Town & Country Planning Act 1990 (as amended)
Town and Country Planning (Development Management Procedure) (England) Order 2015
Application for approval of matters reserved by condition imposed under LU/20/17/PL relating to
conditions 3 for schedule of materials & finishes, 4 for surface water drainage & 5 for scheme to
deal with risks associated with site contamination.
Land adjacent to Shell Garage Worthing Road, Littlehampton,

Arun District Council have decided to **REFUSE details reserved by condition for the following reasons:**

Therefore, at this time Condition 4 cannot be discharged.

Engineering Layout

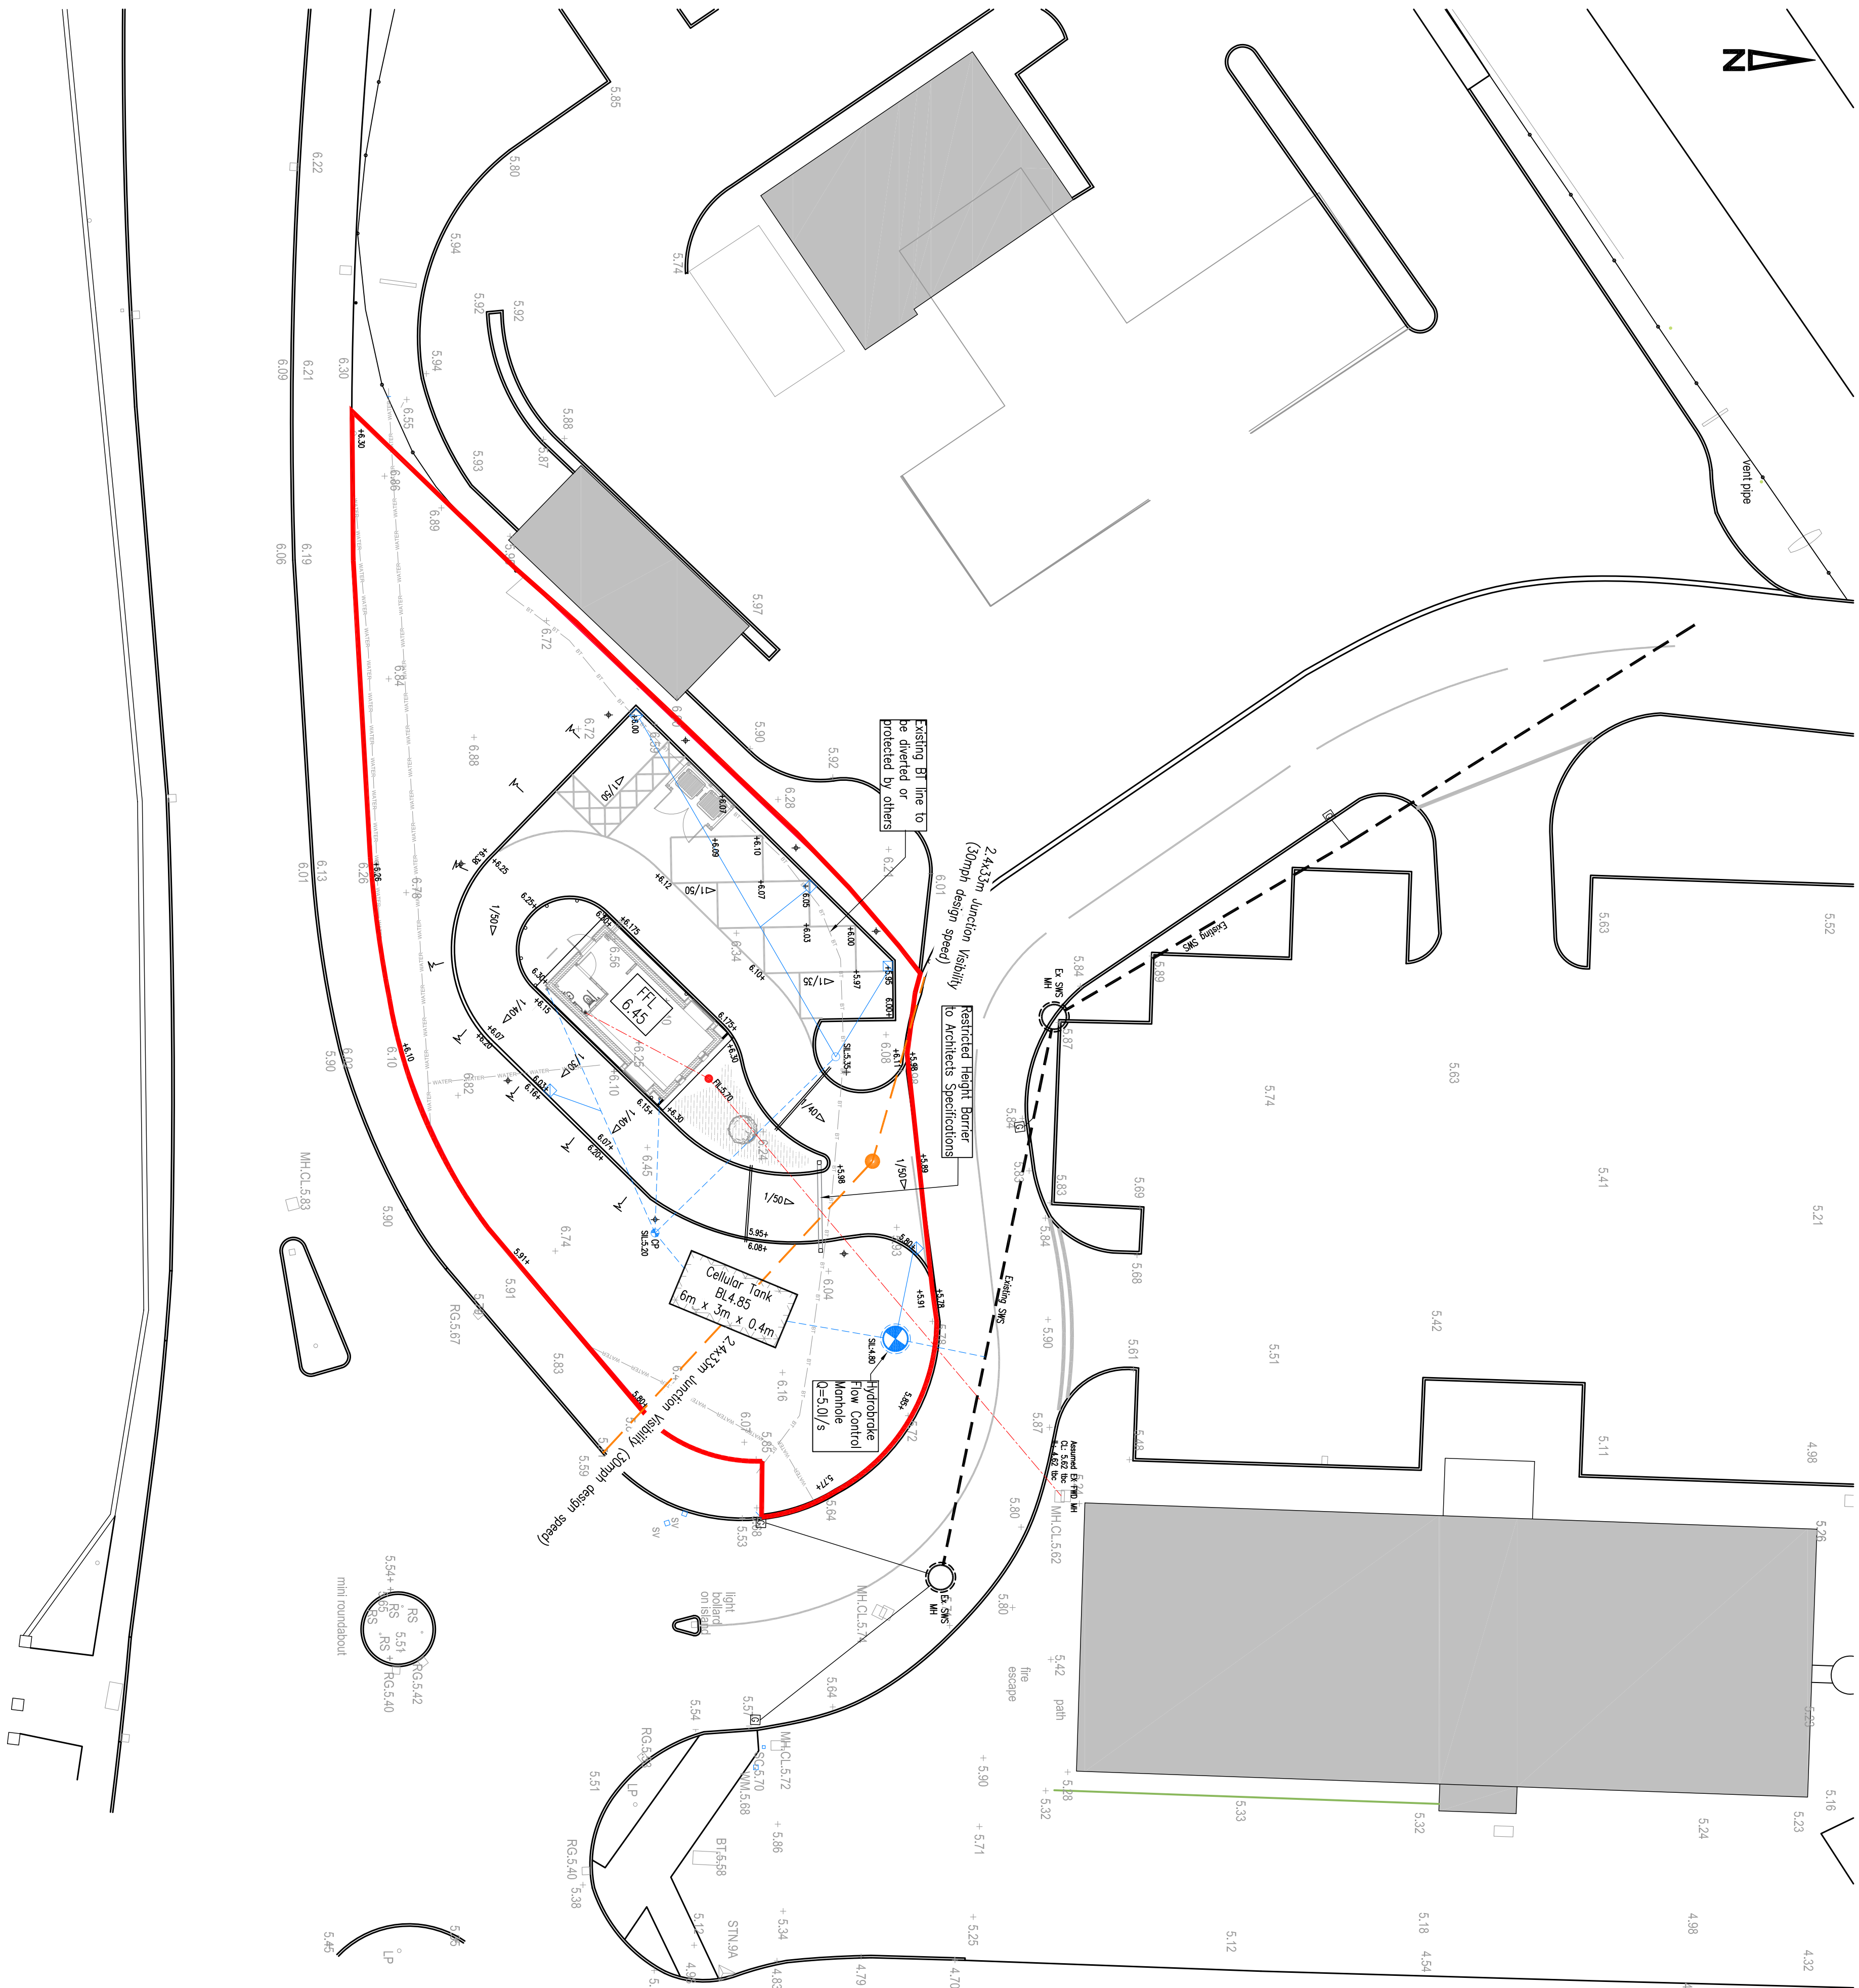
It is intended for surface water to be discharged to the adjacent existing surface water drainage system at a restricted rate. However, they appear not to have fully investigated infiltration methods.

This needs to comprise of satisfactory winter groundwater monitoring and percolation testing at agreed depths/locations. Soakage must be fully considered as per Approved Document H

and national/local guidance, before other options are contemplated.

If soakage ultimately proves not to be feasible, then more information will be required on the adjacent existing drainage system which can be discussed in greater detail with the Council's drainage engineers.
